CITY OF ALBUQUERQUE

April 1, 2019

**RE: Mister Car Wash - 98th St. & Volcano Rd.
Grading and Drainage Plan & Drainage Report
Engineer's Stamp Date: 03/27/19
Hydrology File: K08D004**

**RE: MISTER CAR WASH – 98TH AND VOLCANO
GRADING AND DRAINAGE PLAN RESPONSE TO COMMENTS
ENGINEER'S STAMP DATE**

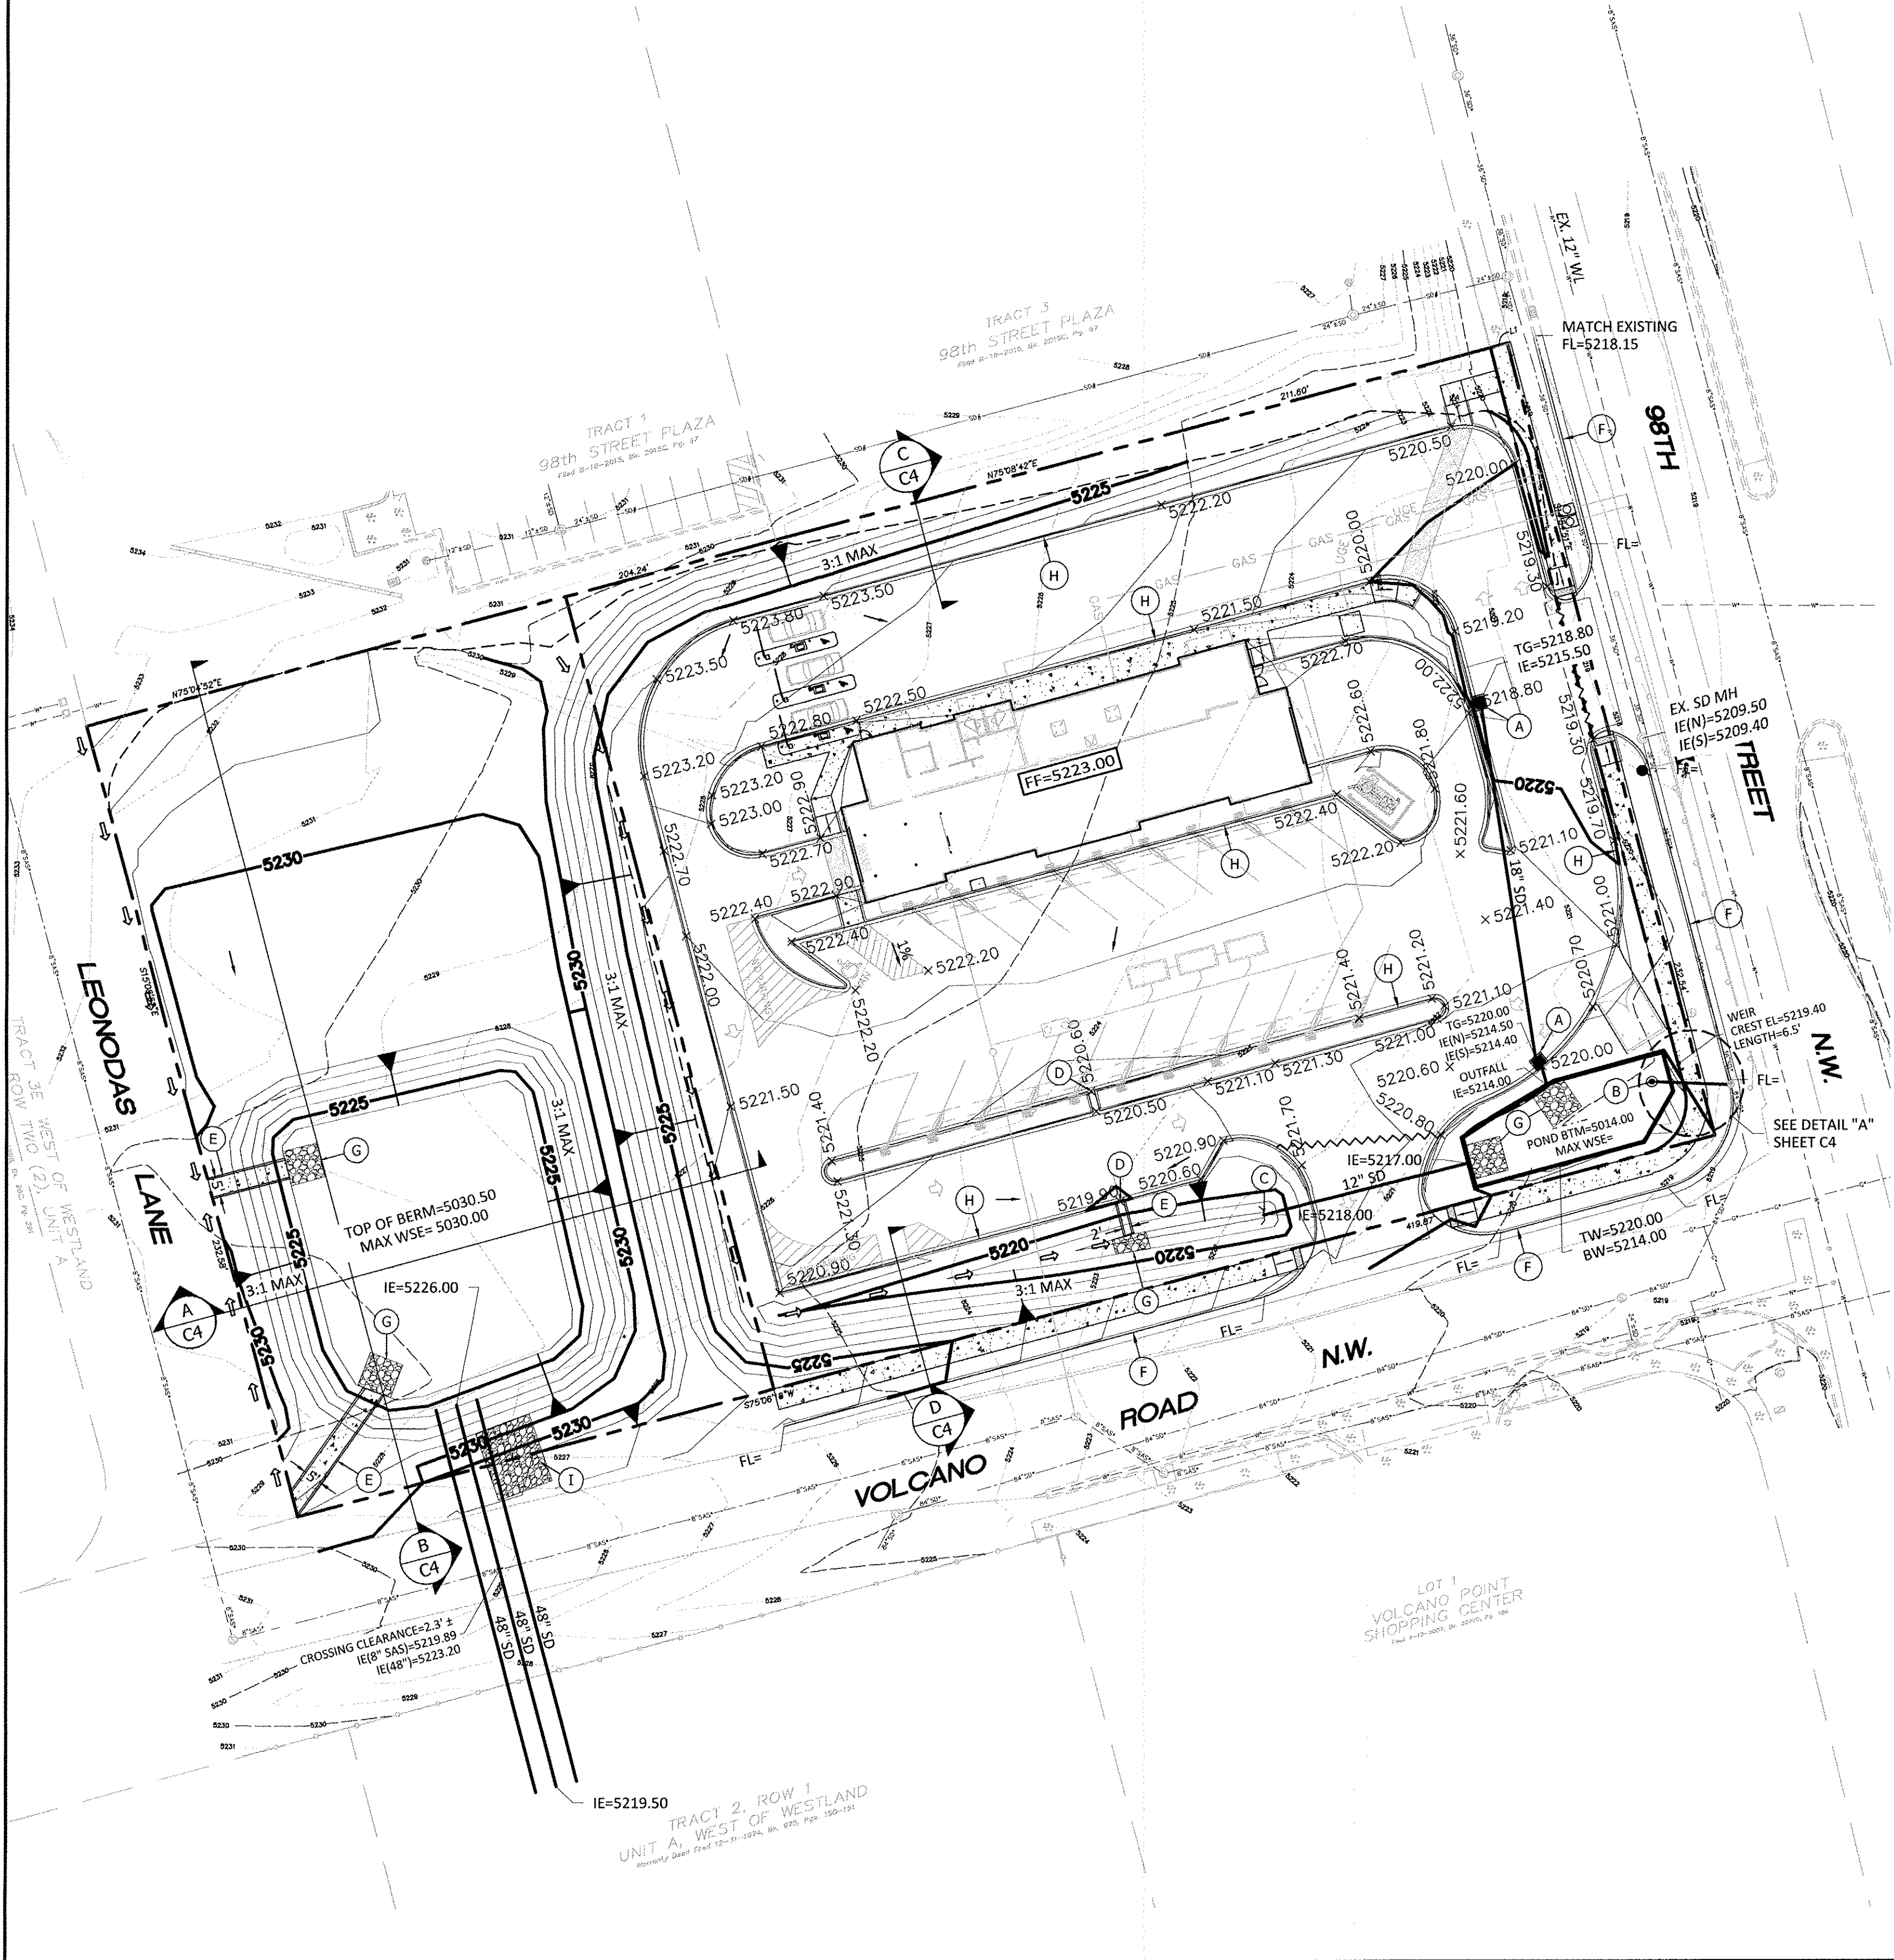
7. Sheet C2. Please either show a swale or revise grades to direct the flows from the off-site basin to Leonidas Lane.
Response: The correction has been made.
8. Sheet C2. Please show the proposed 66 inch storm pipe along 98th St. and add a label stating. "To be constructed with work order."

9. Sheet C2. Please add the flowline elevations along the prop curb on both 98th St. & Volcano Rd.

10. Sheet C2. Please enlarge the area of the stormwater quality pond and remove the proposed contours so that the proposed retaining wall will be shown.

11. Sheet C2. Please add the top of pond and bottom of pond for the City's detention pond.

Response: The changes have been made.

Response: The changes have been made.

Response: The changes have been made.

Response: The elevations have been added.

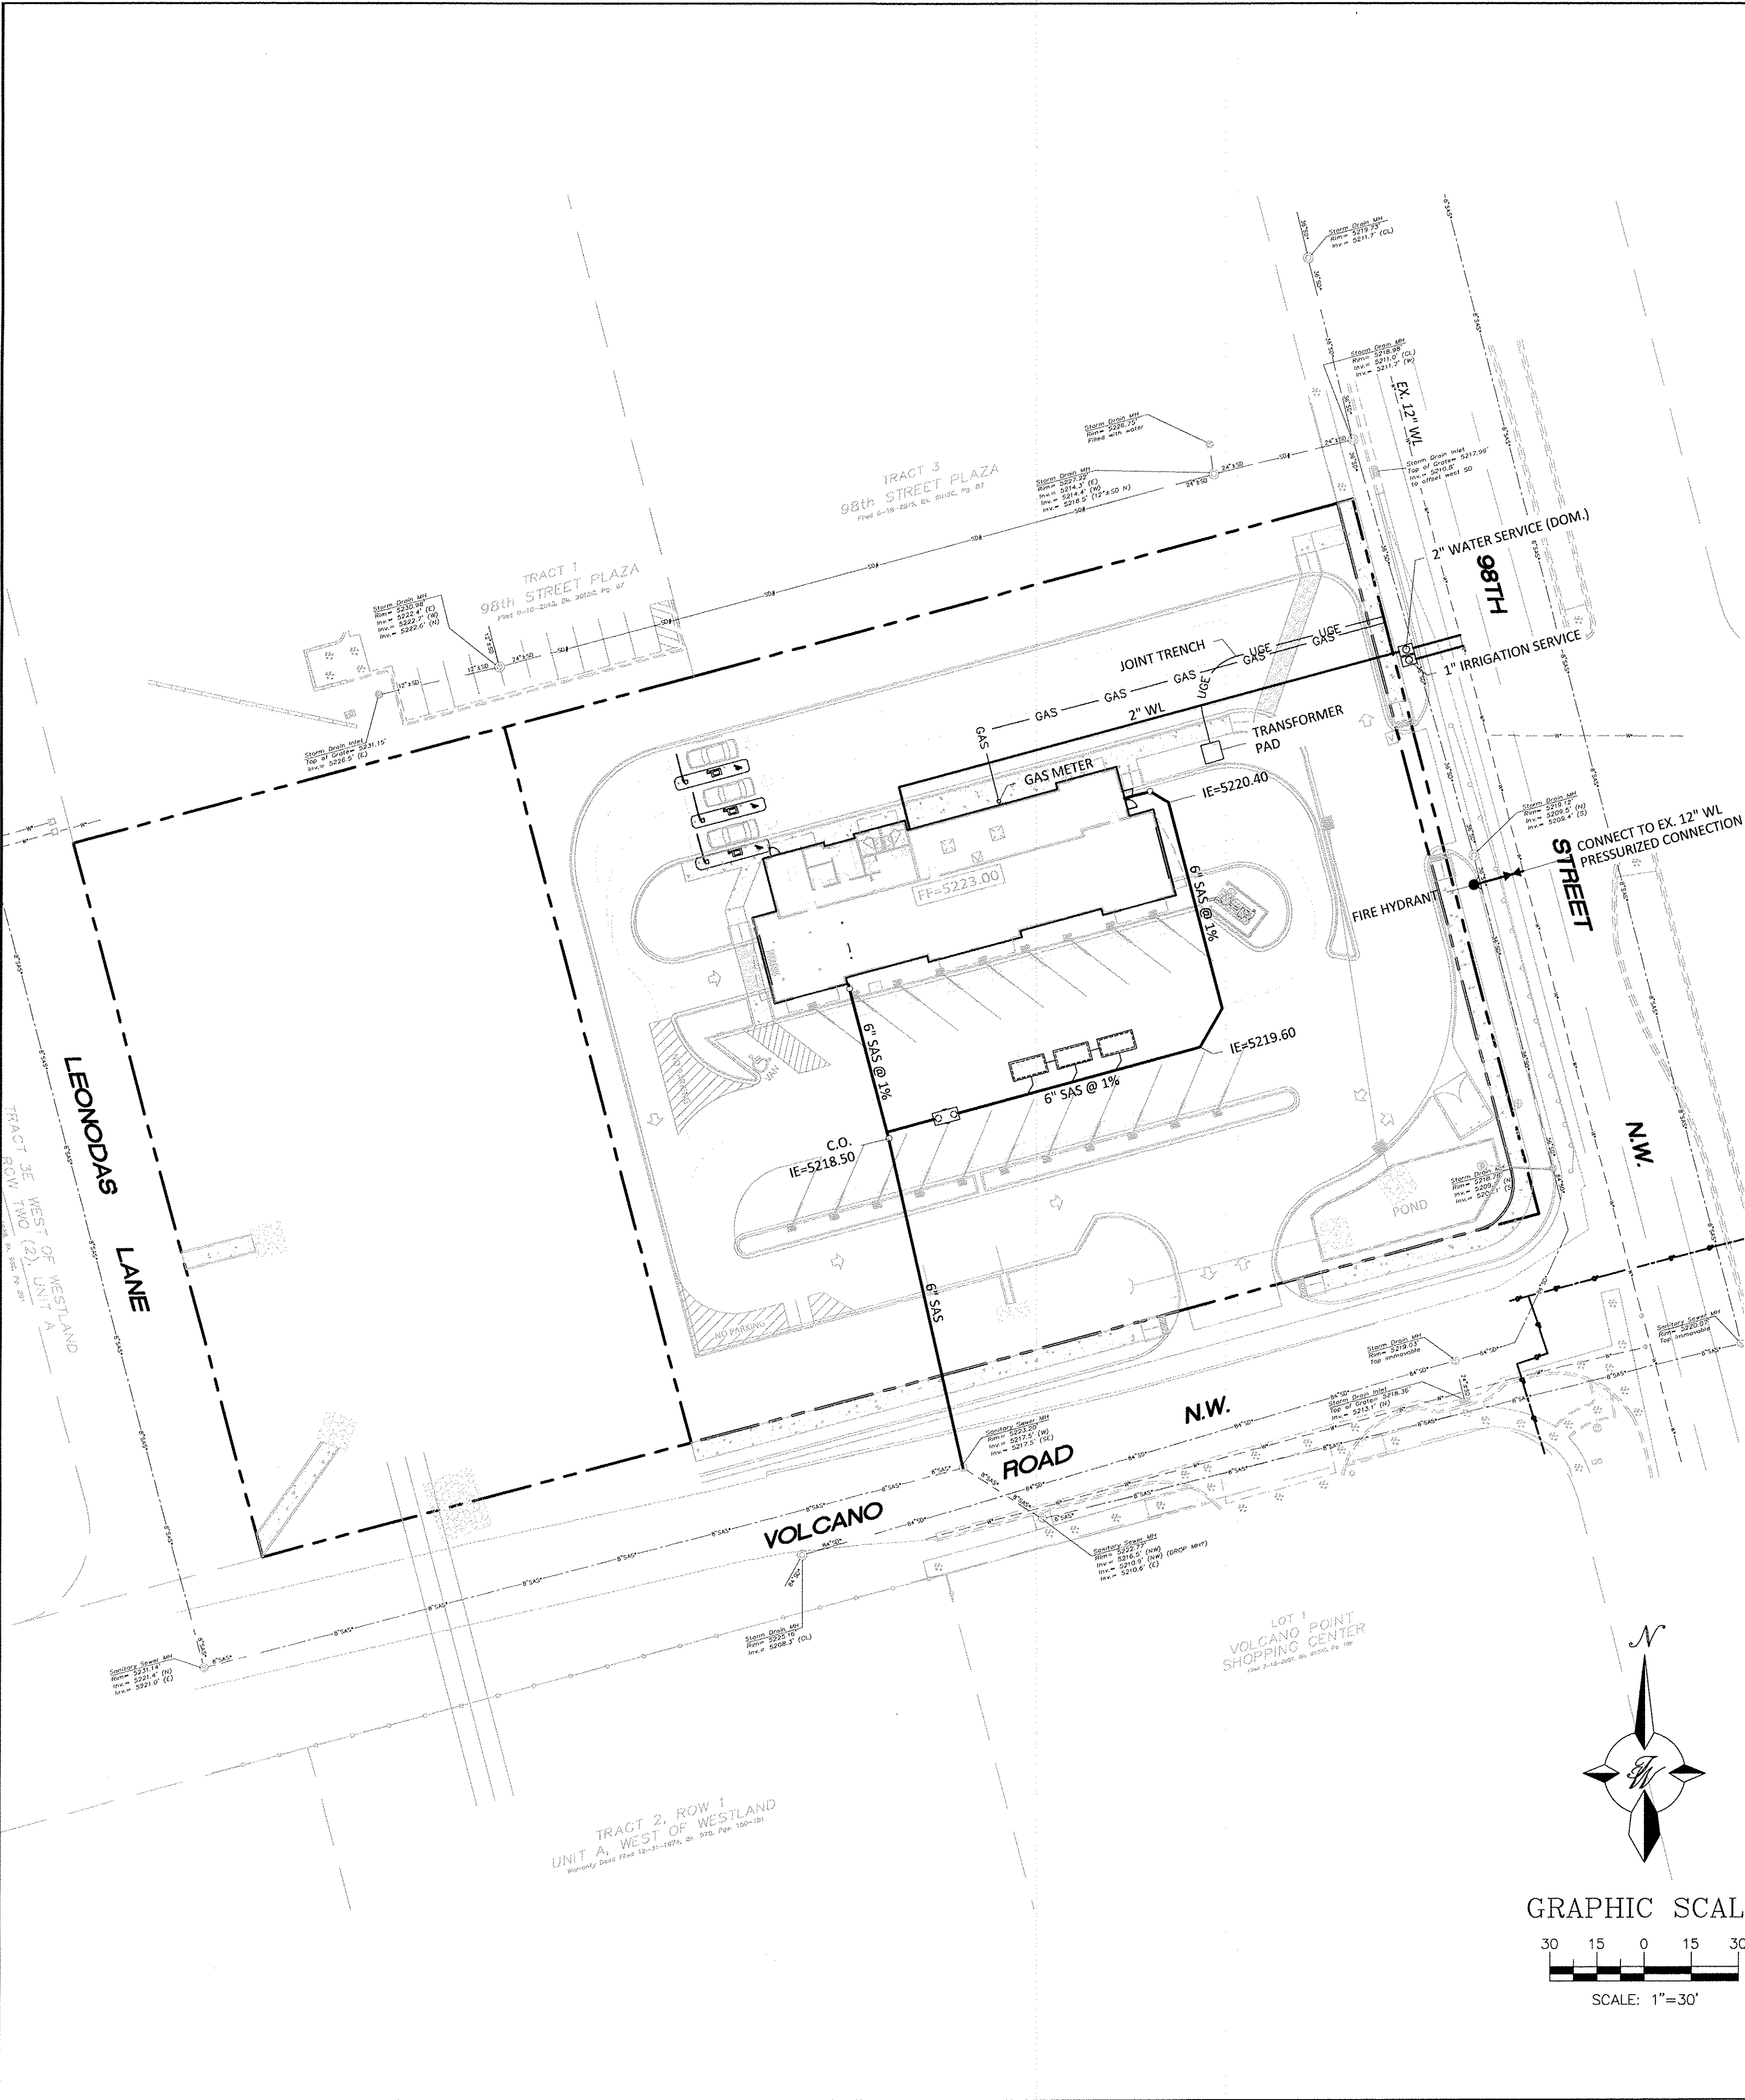
12. Sheet C4. Please add a section showing the 48 inch culverts, temporary pond, Volcano Rd curb & sidewalk, the existing City Pond, and the existing 8" sanitary sewer. Also add the clearance for the sanitary sewer and the top of the storm pipe.

13. Sheet C4 – Detail "A". Either change the pipe from HDPE to RCP or add a converter from HDPE to RCP at the R.O.W. and add the detail from ADS.

Response: The detail has been added to sheet C4.

Response: The detail has been added.
